415 Cumberland Ave - Revised CMP

Please see revised construction management plan for 415 Cumberland Ave. Please review and get back to me with any comments.

-We will be installing jersey barriers along the building on Forest Ave creating a 42" walkway between the curb and the barrier. A HC ramp that allows ADA access will be installed. (previously approved)

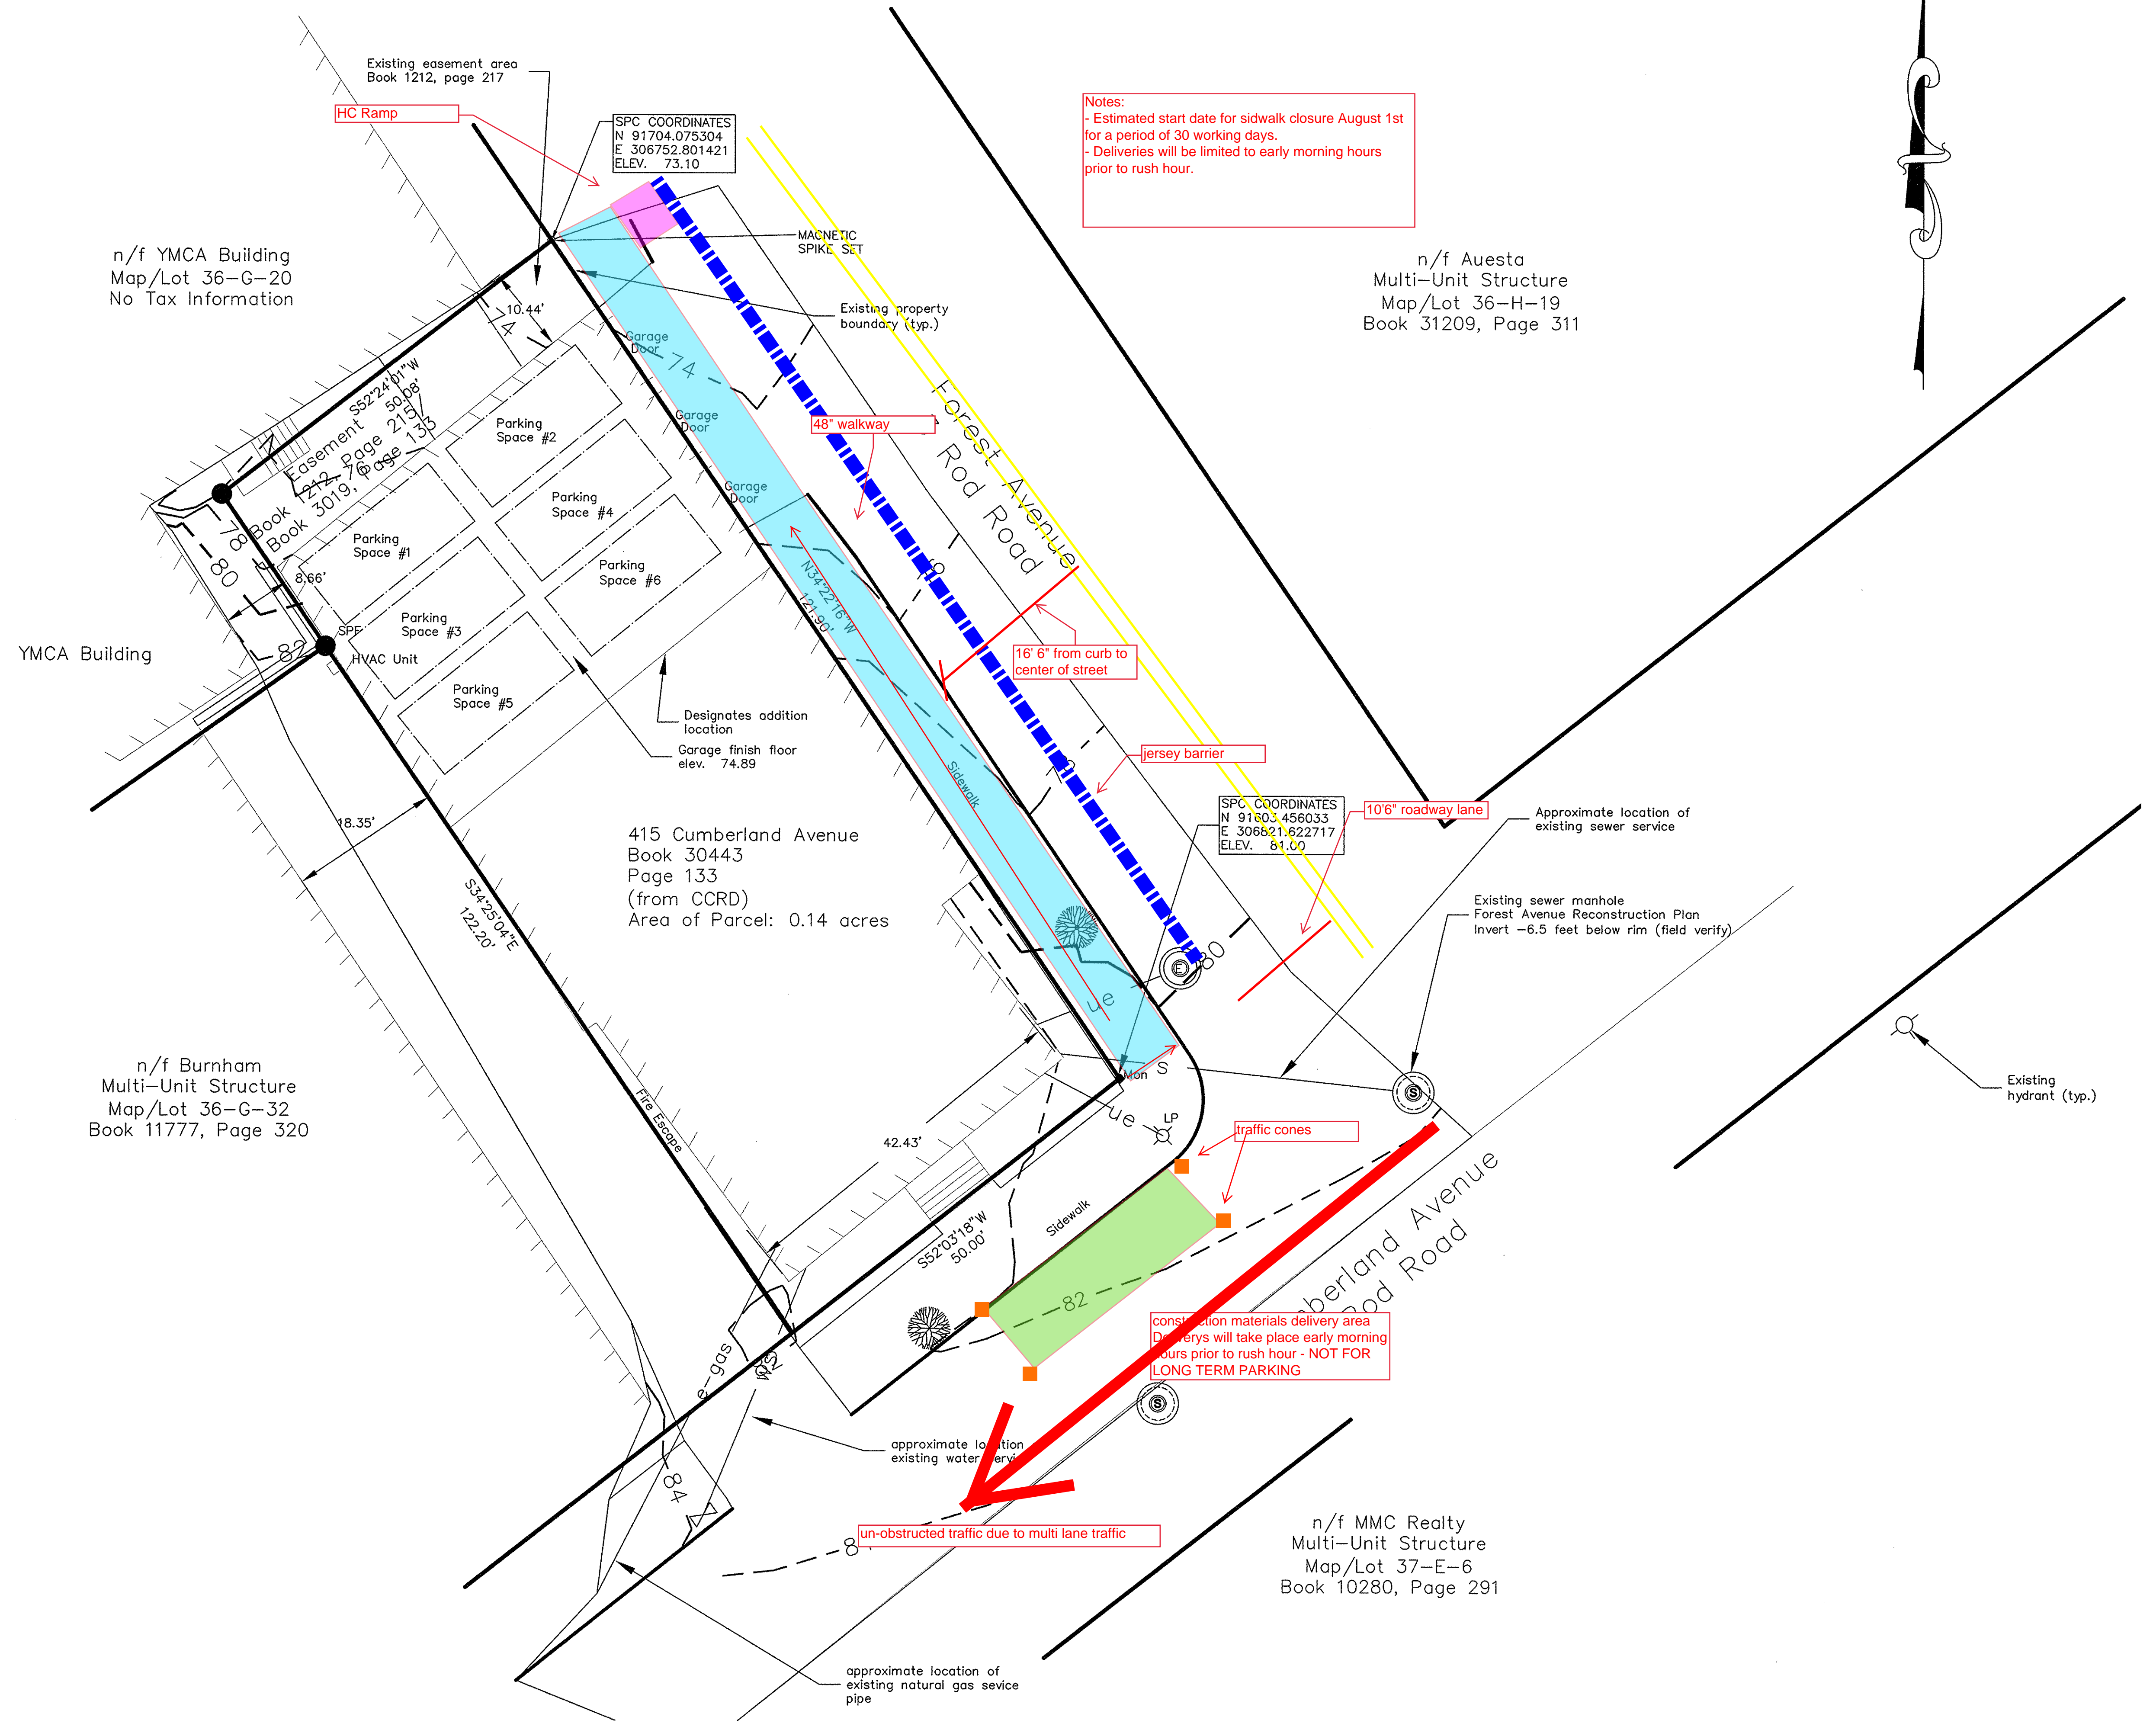
I don't want pedestrians walling around the manlift. If you look at the attached google image, you will see there is not a lot of sidewalk real estate there for an 8'x8' manlift, mast pole and the slope of the ADA panel.

Watching pedestrians walk this, I don't see many issues walking on Forest Ave providing the Jacks /guardrail system allow an unobstructed 4 feet at the footprint and has reflective/visible tape on the setup.

I do have concerns rounding the corner. The first is visibility and the second is walking from Cumberland Ave going to Forest Ave. People naturally hug the building side of the sidewalk and with me just standing at the corner, people walked into the street than stepped back onto the sidewalk on Forest Ave at the tree well. It was scary for me to watch. A lot of vehicle movement at this intersection.

I still think you will need the Jersey barriers when you are reconstructing the sidewalk. I also have concerns about work occurring overhead of pedestrians and I would prefer there be some horizontal distance between the overhead work and the walkway.

Yes Jodie. We need that physical separation regarding both potential overhead conflicts and accommodations in Forest Avenue. Jersey barriers will be a must here.

- The area in the front of the building on Cumberland Ave. will be occupied by a man lift. The sidewalk will be closed to pedestrians. Signage will be placed on the corners of Cumberland Ave and High Street as well as the NE corner of Cumberland Ave and Forest Ave. The signs will direct the pedestrians to cross the street at the existing crosswalks and tip downs, safely avoiding the work area on Cumberland Ave.
